Medworth Energy from Waste Combined Heat and Power Facility

PINS ref. EN010110
Document Reference: Vol 9.20
Revision: 3.0
Deadline 3
April 2023

Schedule of Changes (Deadline 3)

Key

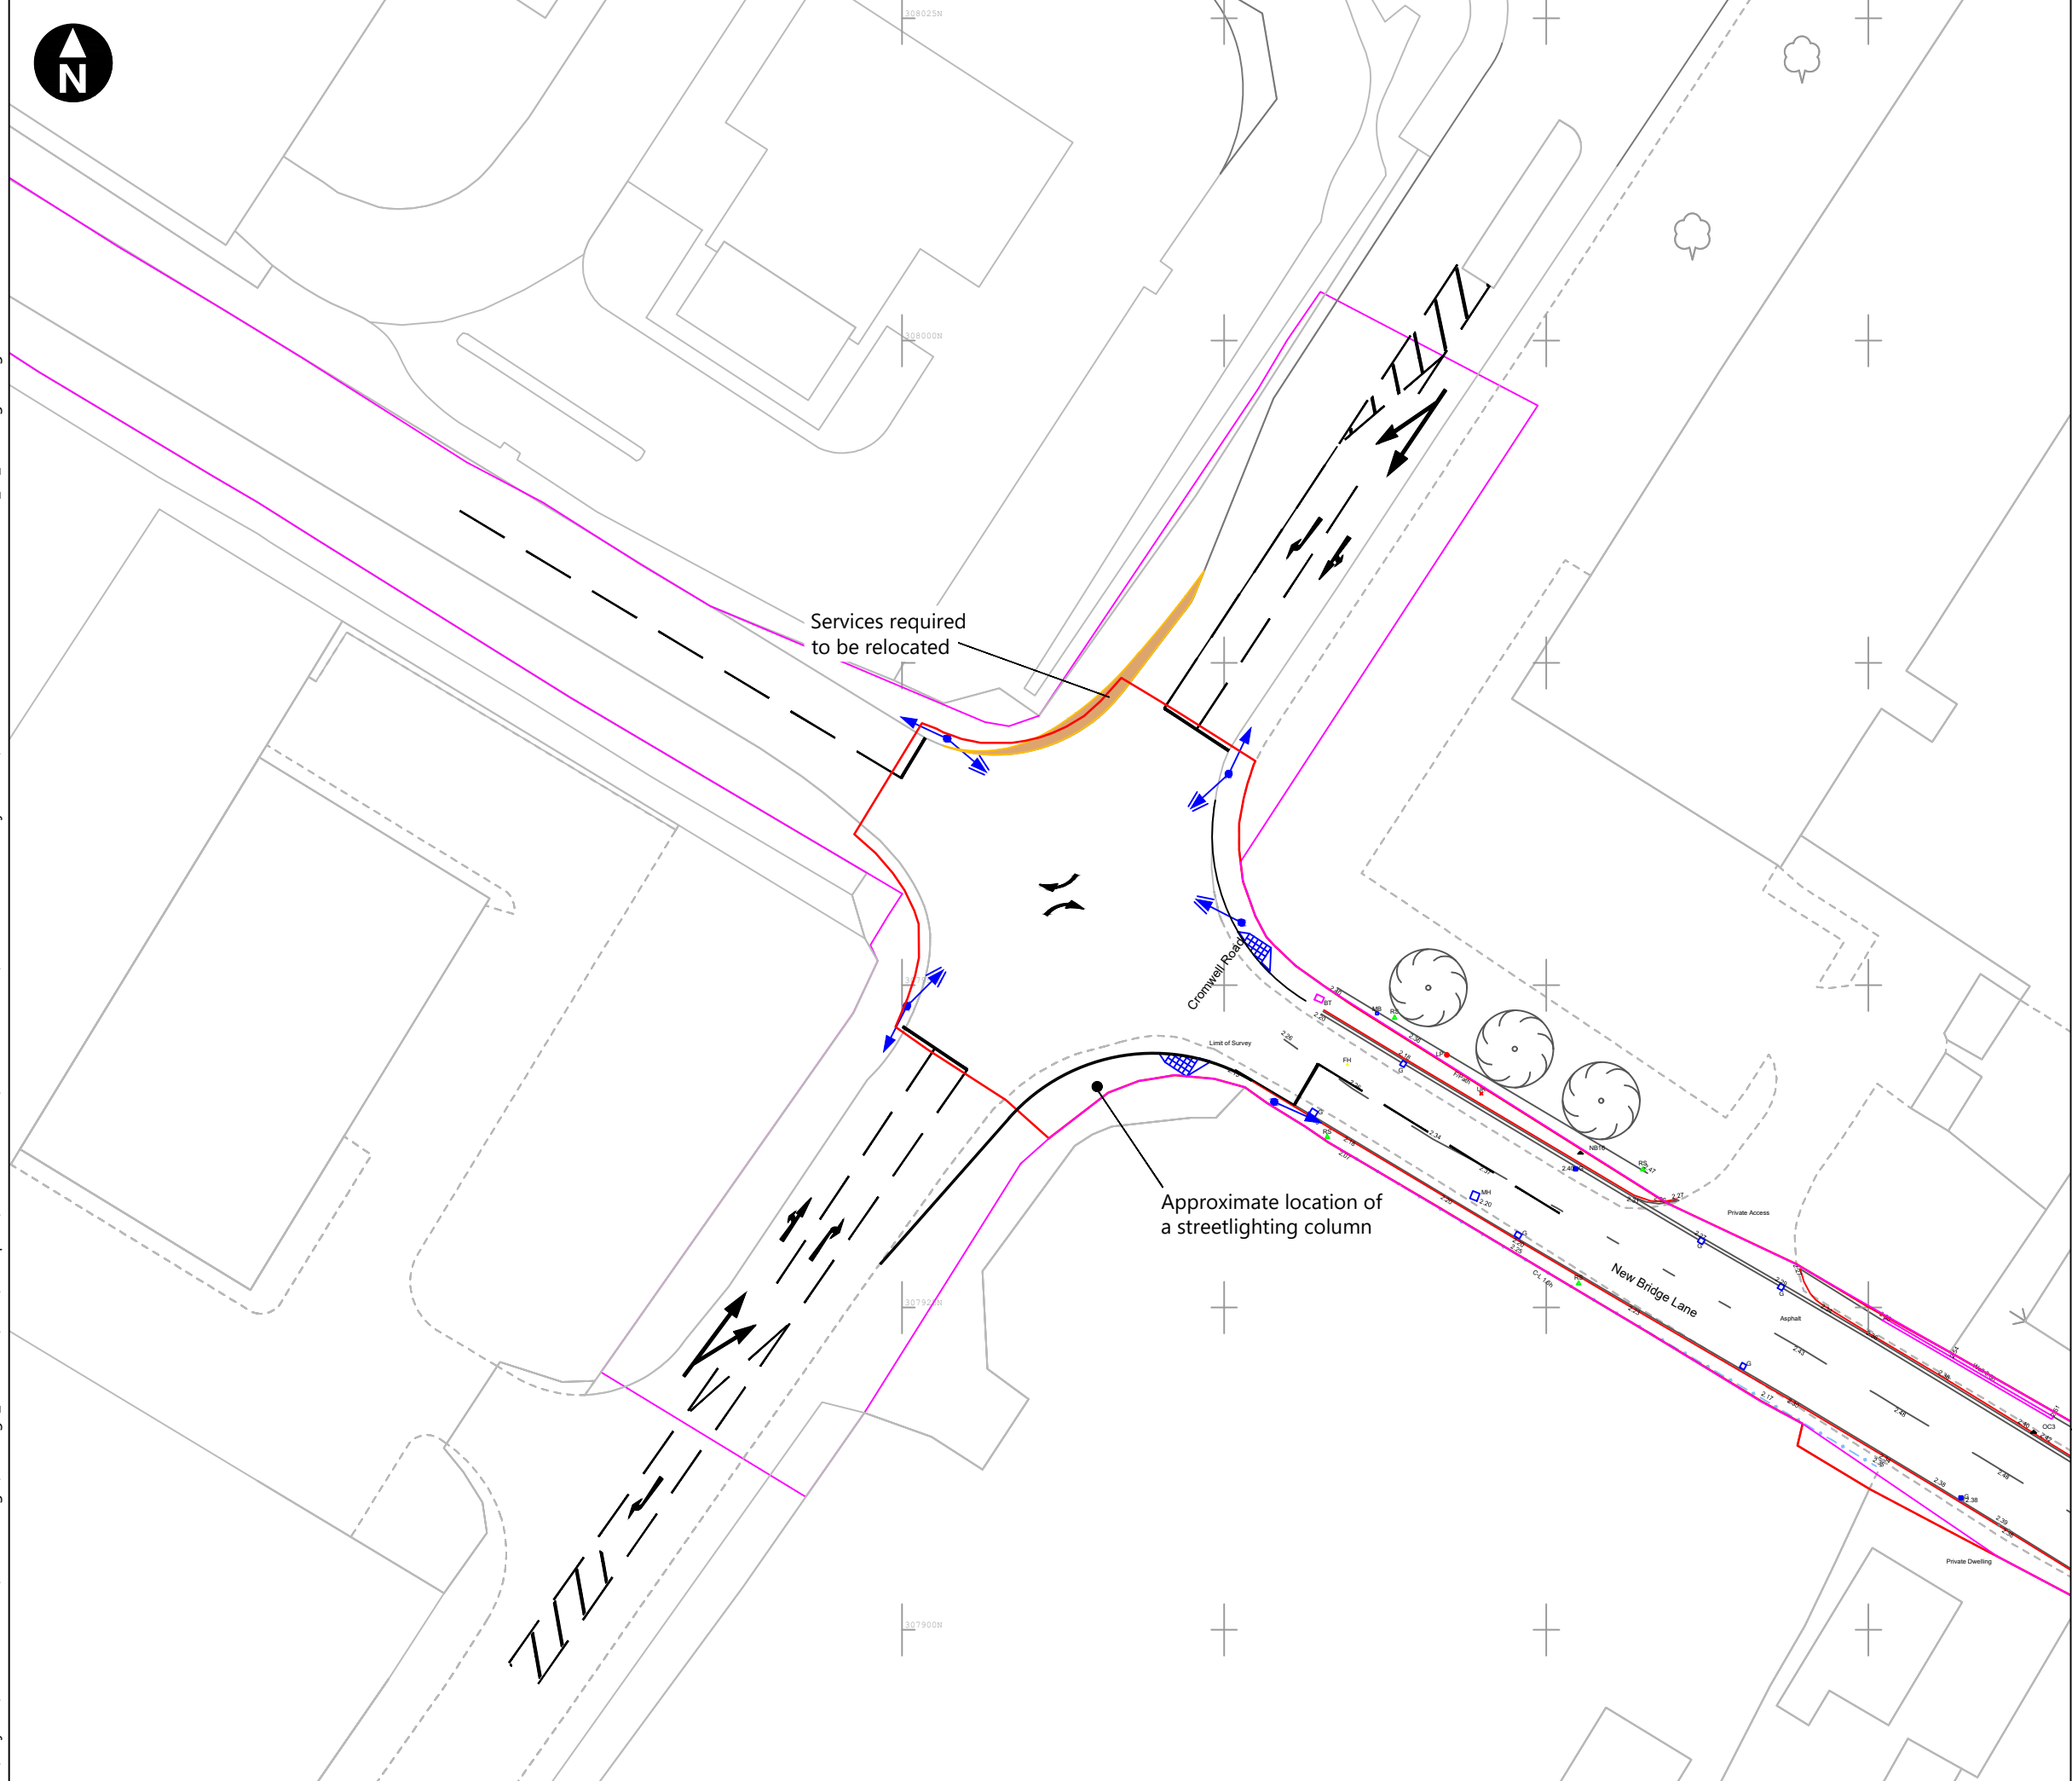
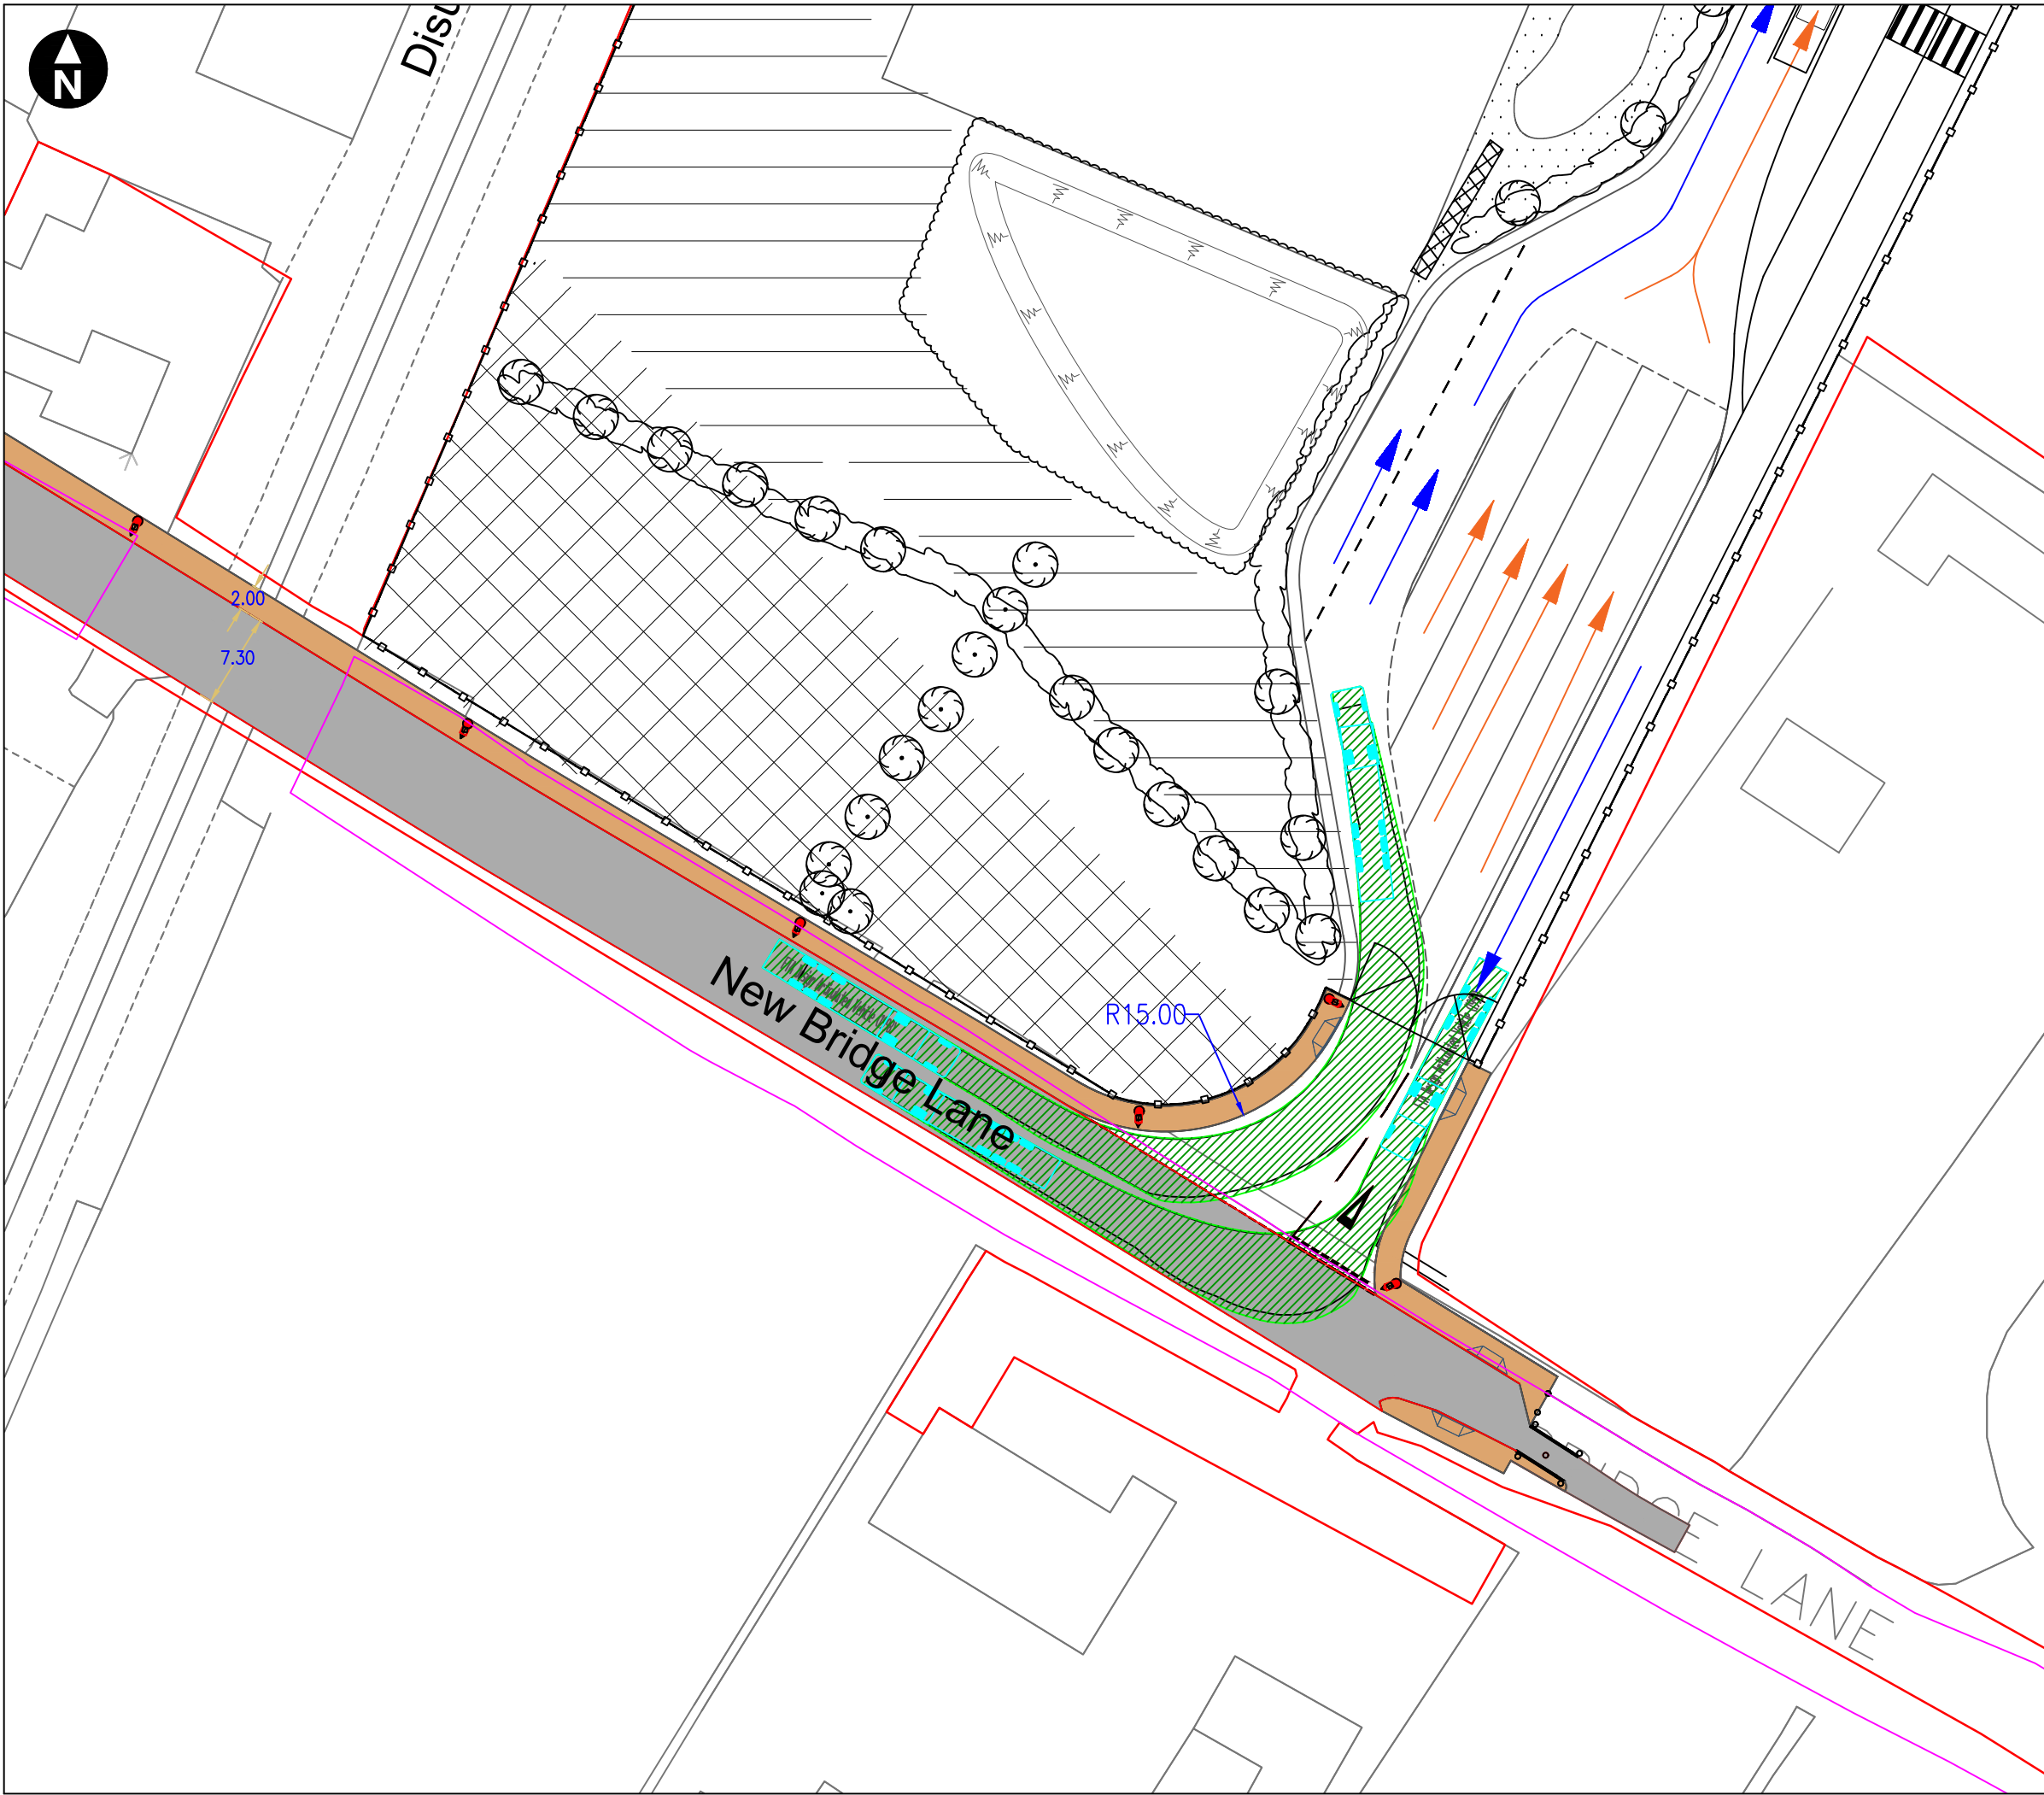
Document Updated	Change	Reason for change	Deadline submitted	Relevant Document version
Volume 6.4 ES Chapter 6 Traffic and Transport Appendix 6A Outline (CTMP) [REP1-011]	Paragraph 7.4.8 – additional paragraph to confirm that the Applicant, with the agreement of Network Rail, will retain/reposition/provide a sign setting out the rights of access applicable to NMUs at the point that New Bridge Lane crosses the Disused March to Wisbech Railway.	CCC and FDC LIR paragraph 2.4.3 [REP1-074] .	Deadline 3	Rev 3
Volume 6.4 ES Chapter 6 Traffic and Transport Appendix 6A Outline (CTMP) [REP1-011]	Additional drawings, Figures 9.2ii to show swept path of vehicle leaving New Bridge Lane. Also Figure 10.3i – ii to show outline design for construction accesses into the CHP Connection Corridor from Weasenham Lane and accompanying swept path.	CCC and FDC LIR paragraph 2.7.32 and 2.7.34 [REP1-074] .	Deadline 3	Rev 3
